CITY OF PORTLAND

BUILDING PERMIT

Job ID: 2012-10-5292-ALTR

has permission to Second floor addition, exterior deck, and interior renovations (Single Family Residence) provided that the person or persons, firm or corporation accepting this permit shall comply with all of the provisions of the Statues of Maine and of the Ordinances of the City of Portland regulating the construction, maintenance and use of the buildings and structures, and of the application on file in the department.

34 to 38" Graspable Rail

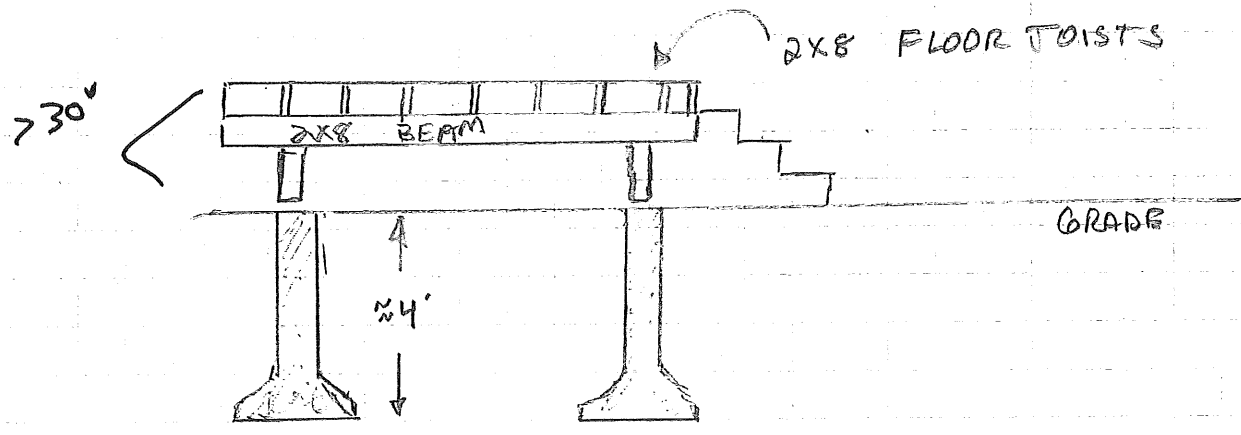
5. A graspable handrail (34-38 inches in height) shall be provided on at least one side of each continuous run of treads or flight with four or more risers. Fall protection (36 inches) from exterior decks may be required if floor joist are at or above thirty (30) inches from grade.

A-101

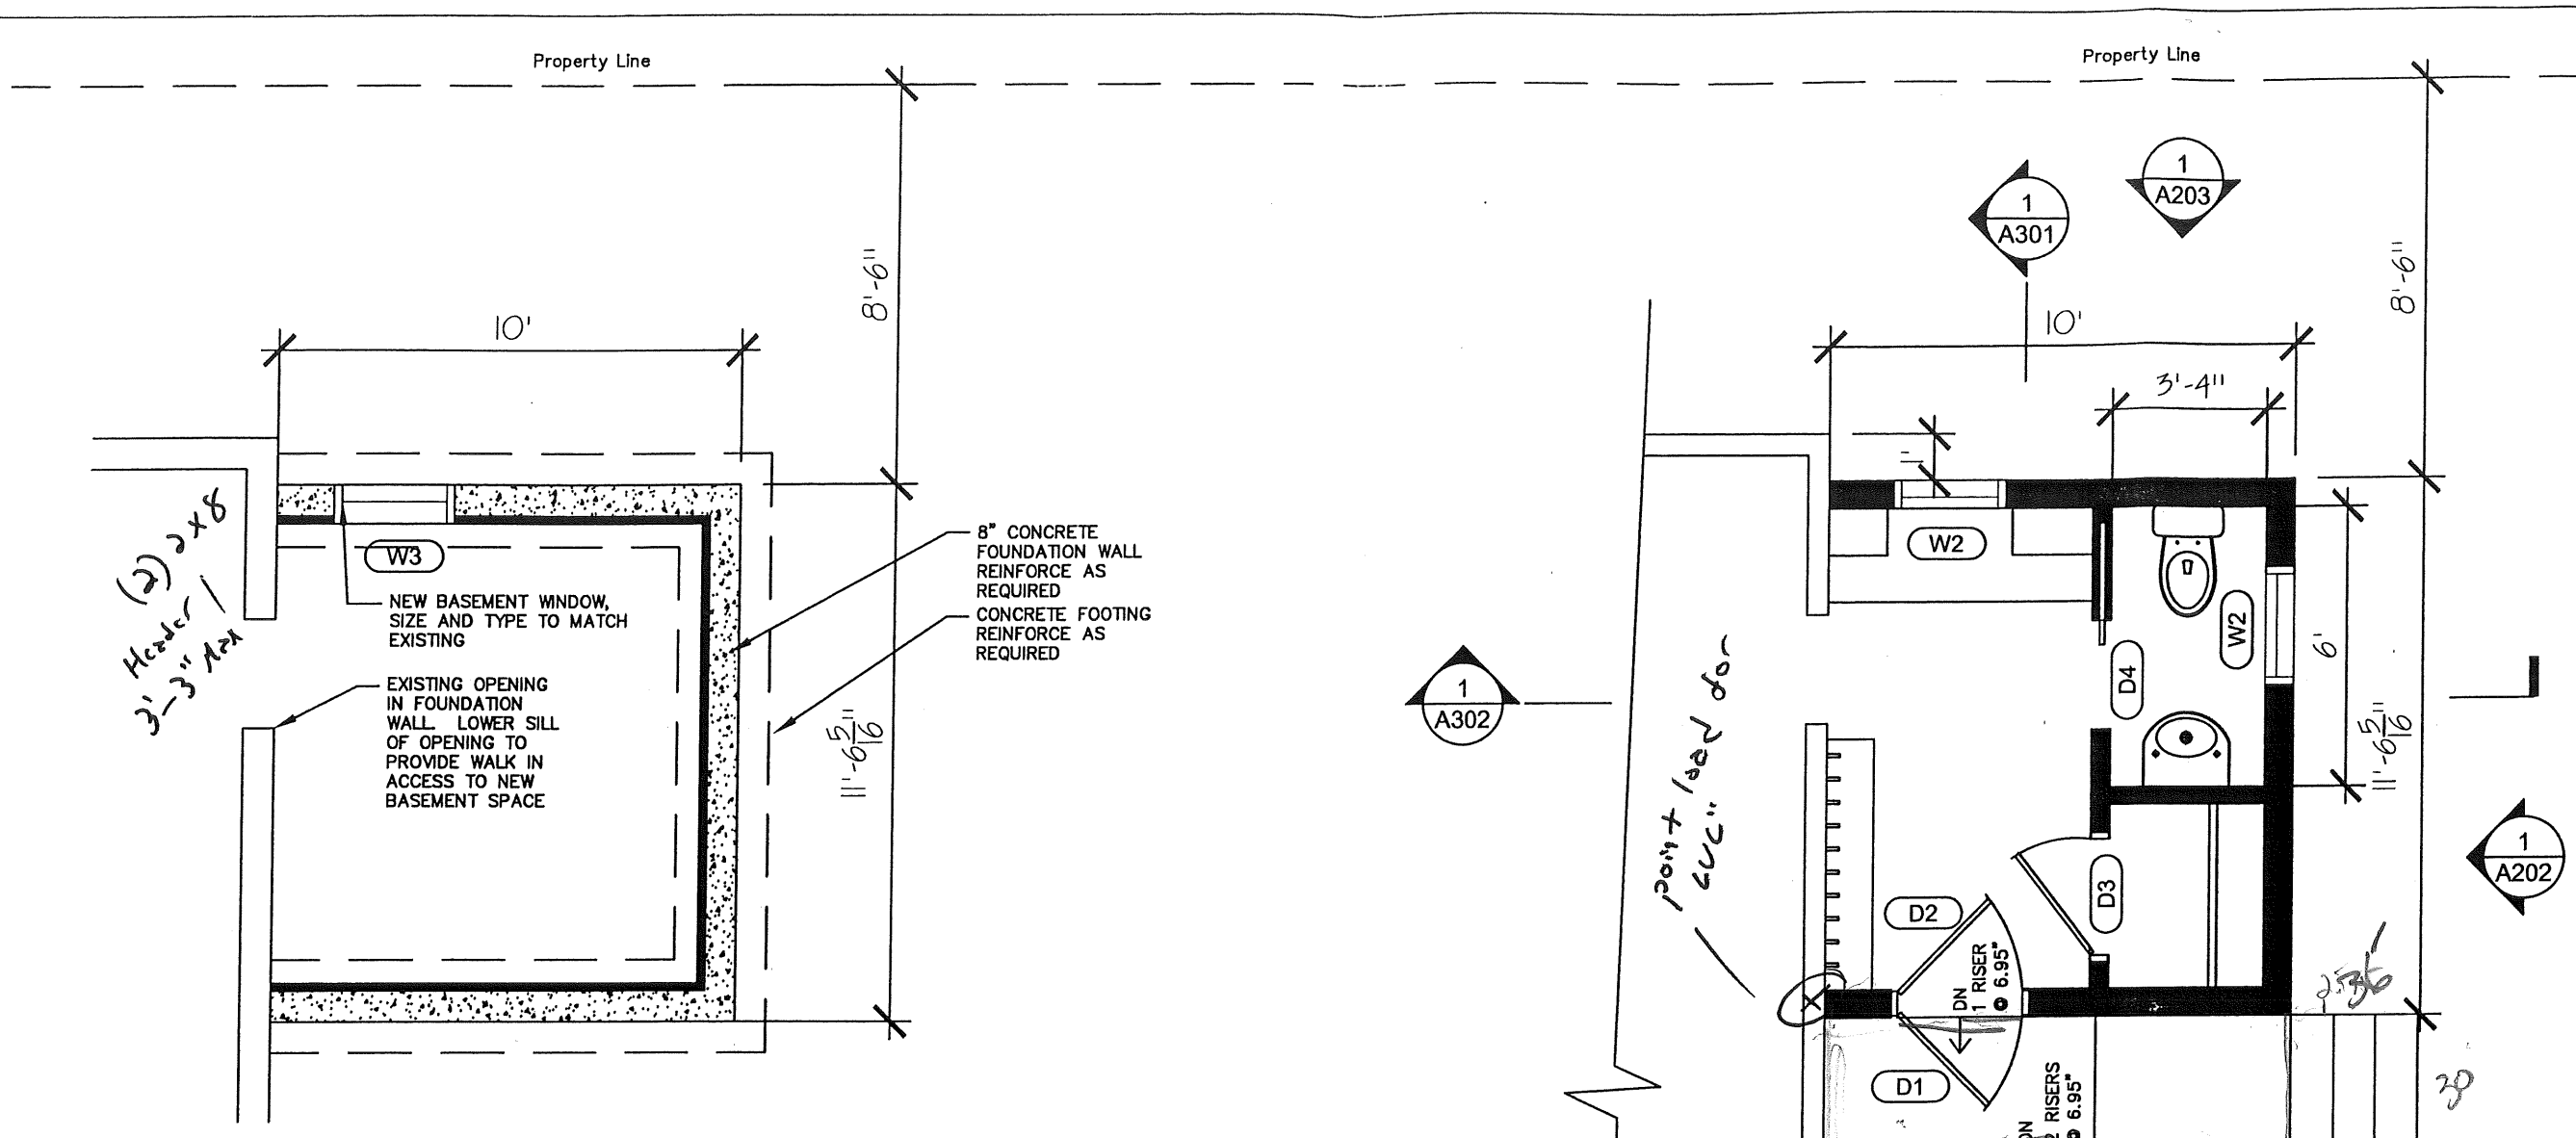
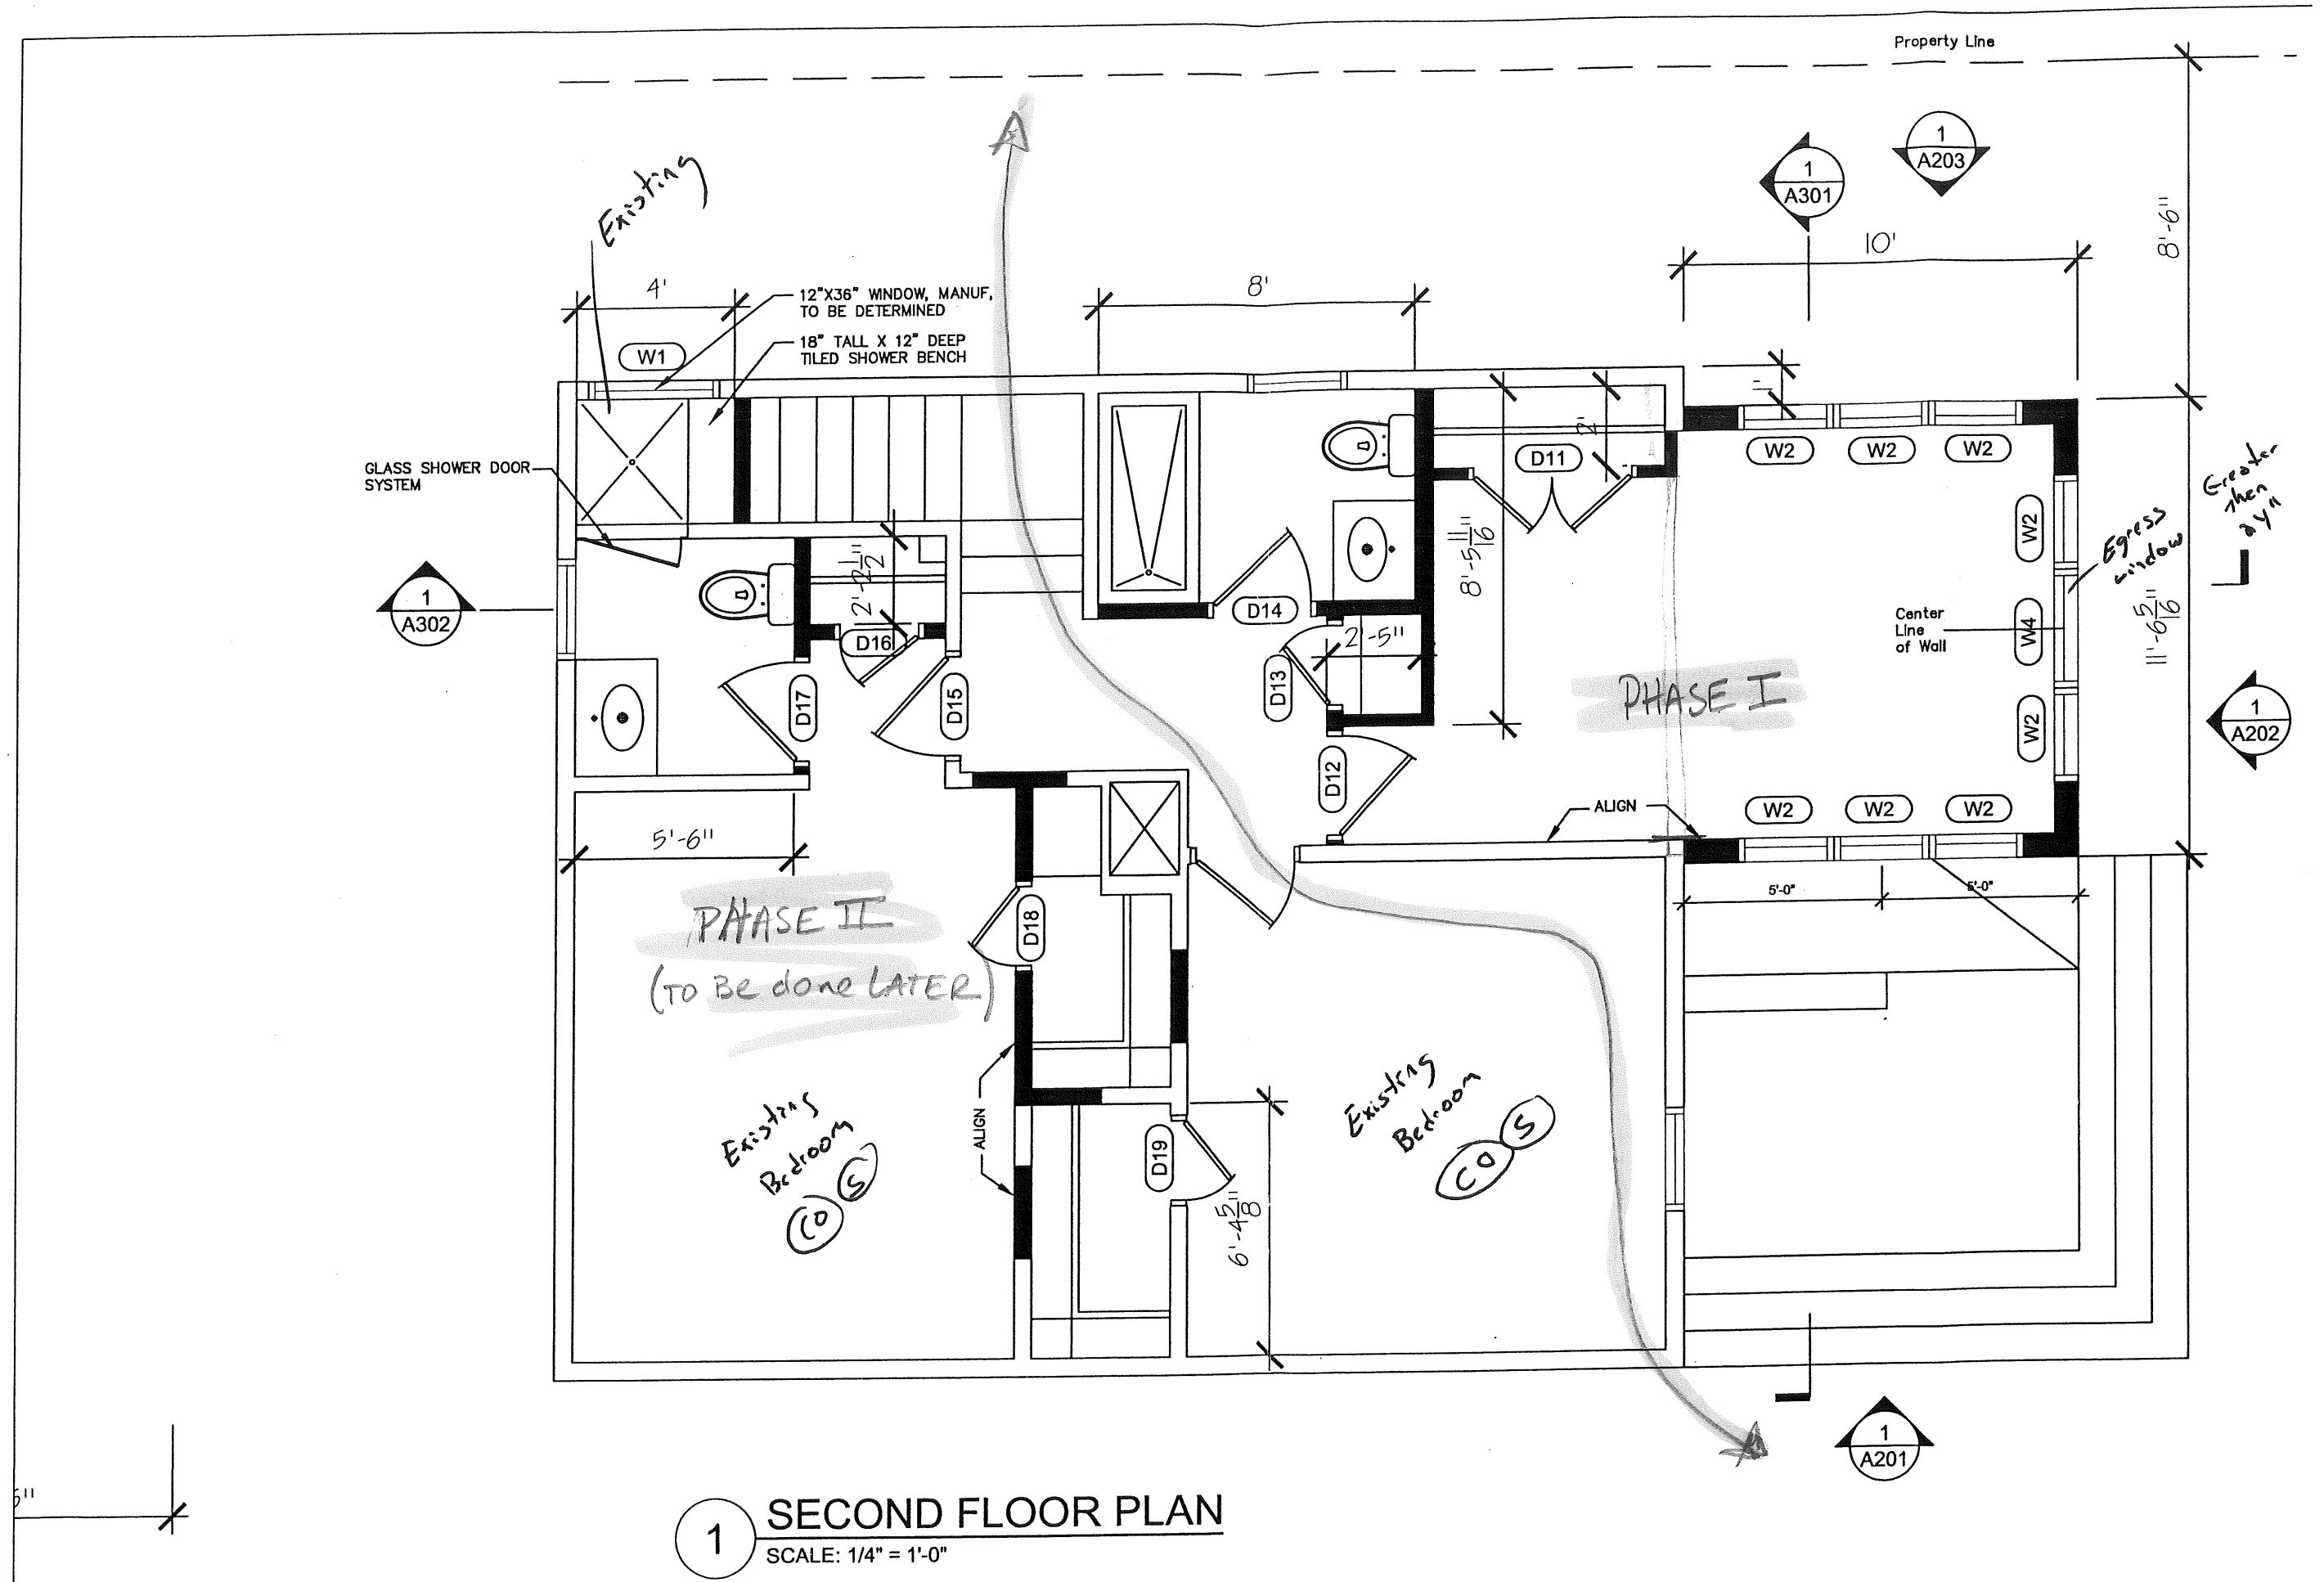
2. Foundation Drainage: Fabric, Damp proofing shall comply with Section R405 & R406, see attachment.
3. Window sills in locations more than 72 inches from finished grade shall be a minimum of 24 inches above the finished floor of the room, unless a window fall prevention devices is installed in accordance with section R612.3.

4. A code compliant emergency escape shall be provided in the proposed bedroom. Window sills in locations more than 72 inches from finished grade shall be a minimum of 24 inches (no higher than 44 inches) above the finished floor of the room, or in compliance with Section R612.4.2 Operation for emergency escape.

13. Notes: Contractor will provide specs for basement egress, and engineered trusses.

A-301

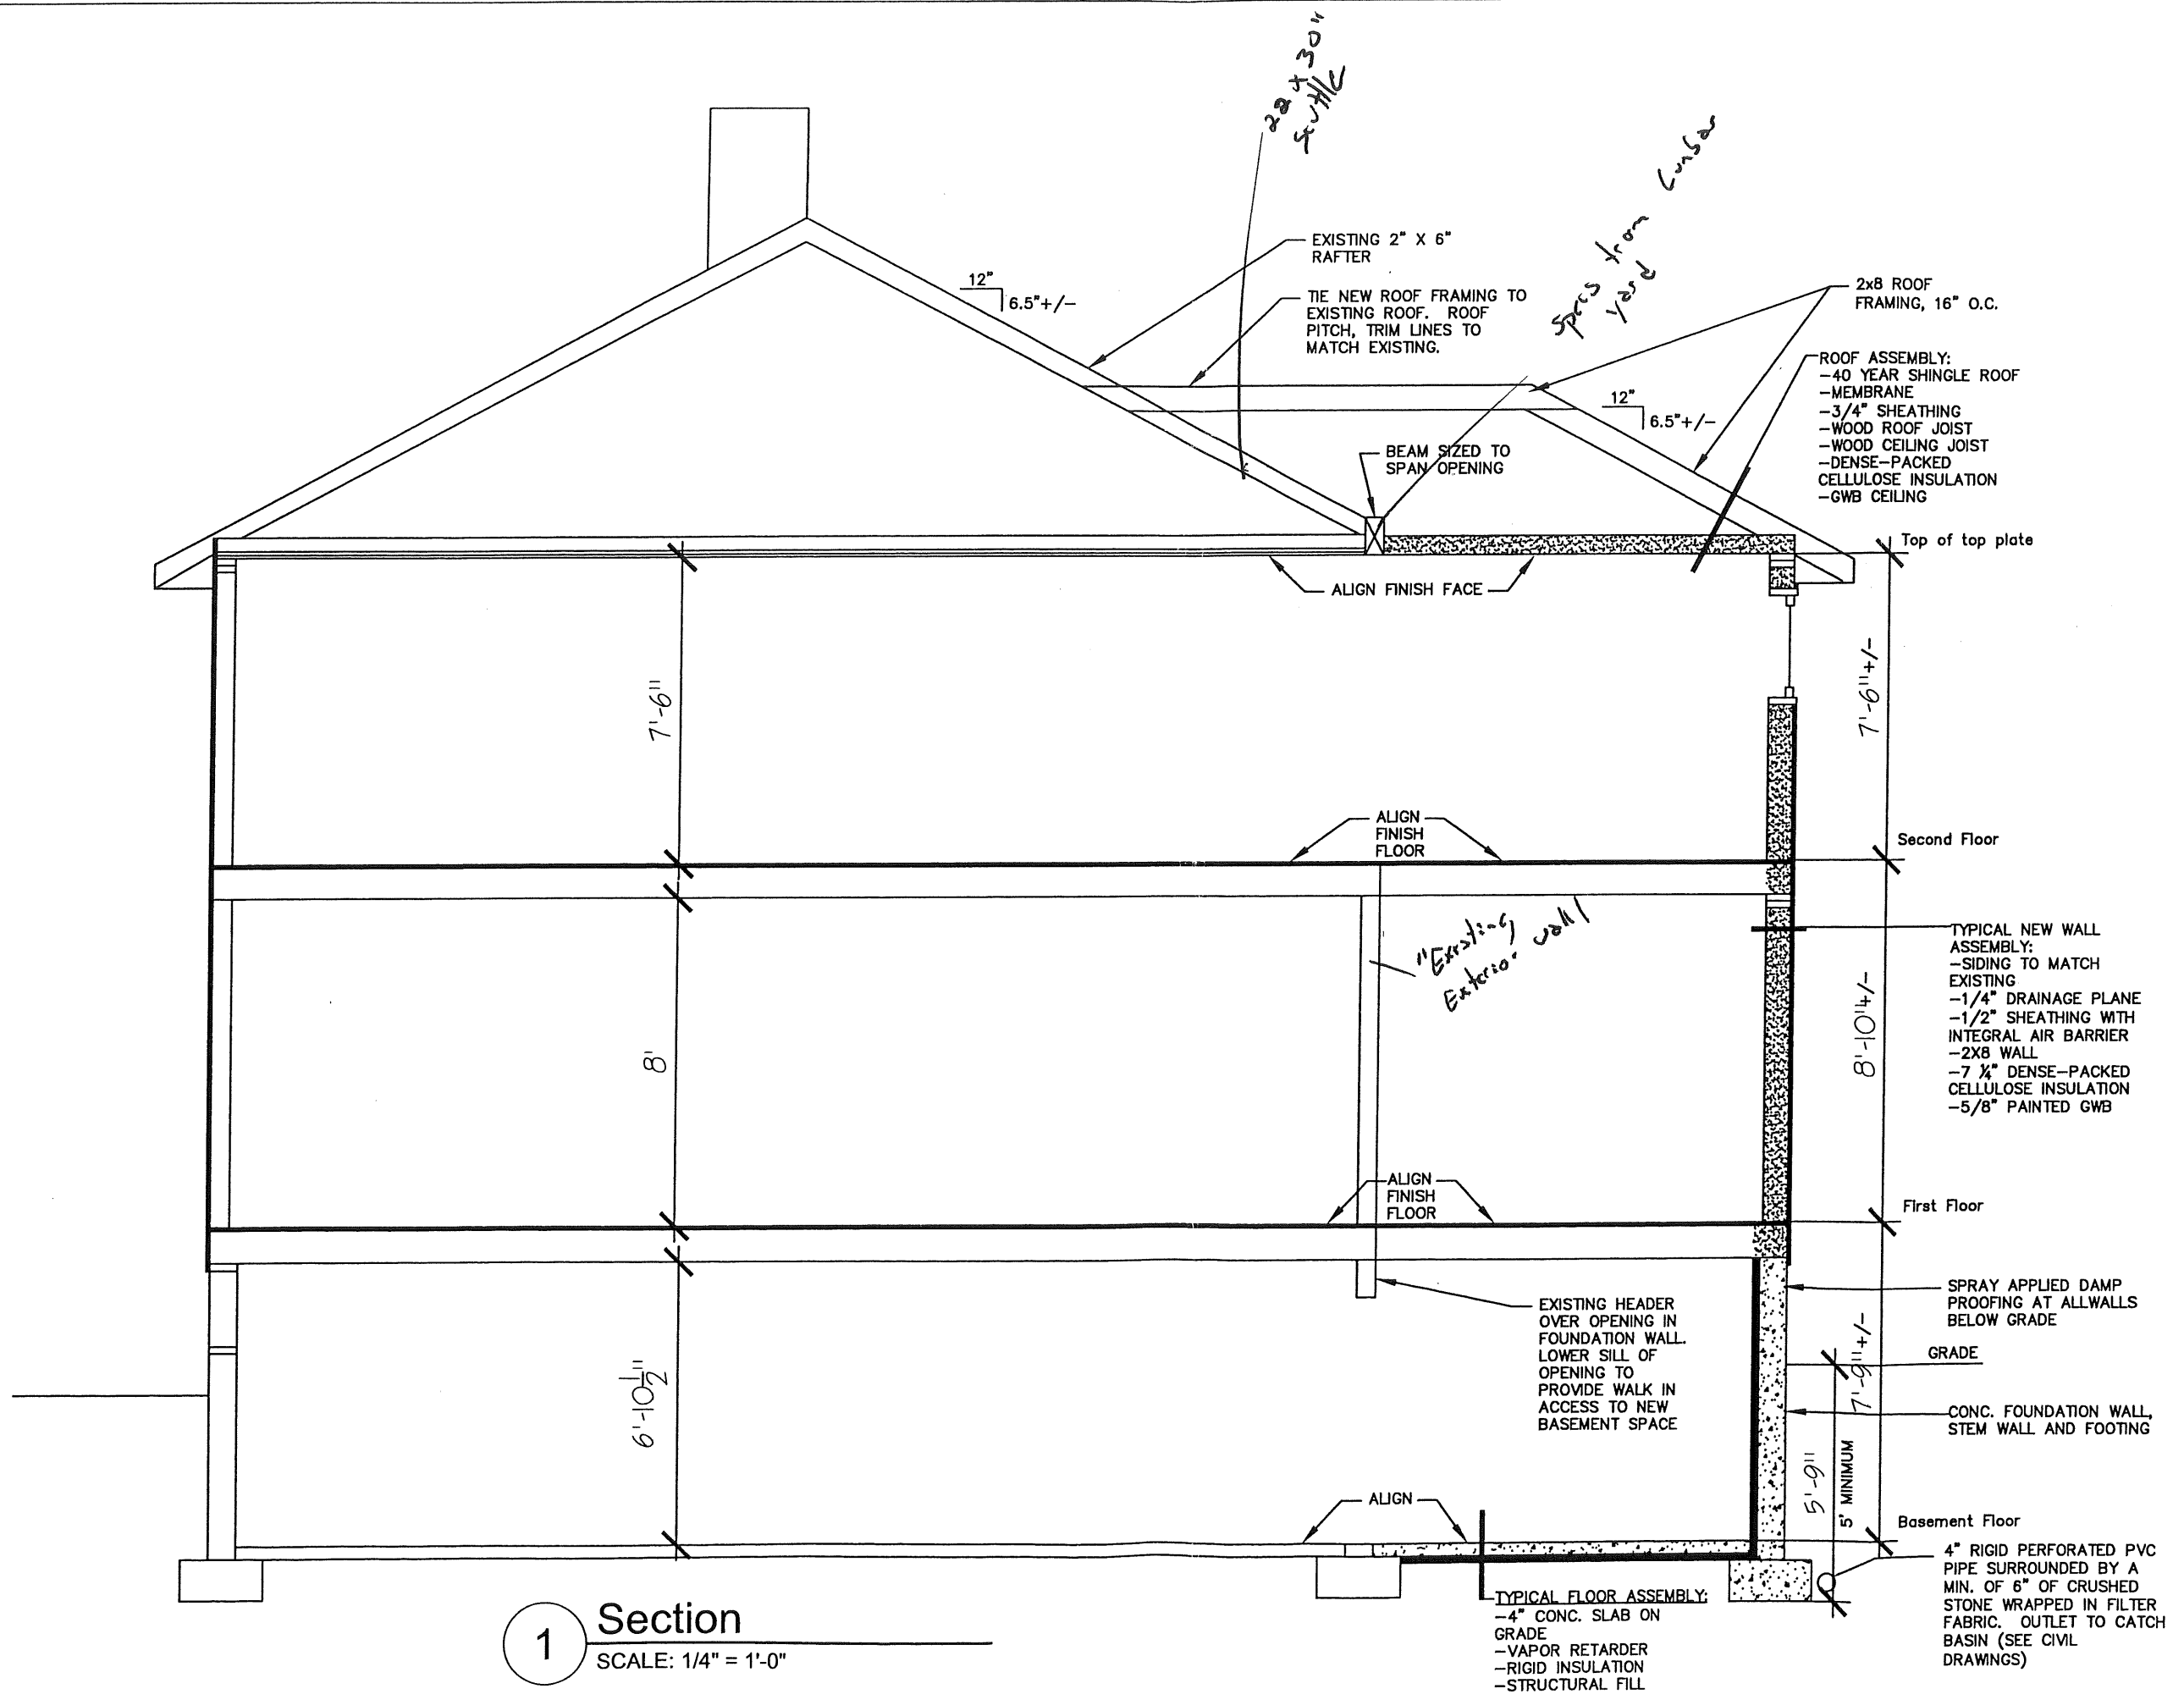
10. R807.1 Attic access. Buildings with combustible ceiling or roof construction shall have an attic access opening to attic areas that exceed 30 square feet and have a vertical height of 30 inches or greater. The vertical height shall be measured from the top of the ceiling framing members to the underside of the roof framing members. The rough-framed opening shall not be less than 22 inches by 30 inches and shall be located in a hallway or other readily accessible location.

11. Roof Rafter framing and Connection shall comply with Section R802.3 & R802.3.1 of MUBEC.
12. R316.5.10 Interior finish. Foam plastics shall be permitted as interior finish where approved in accordance with Section R316.6 Foam plastics that are used as interior finish shall also meet the flame spread index and smoke-developed index requirements of Sections R302.9.1 and R302.9.2.
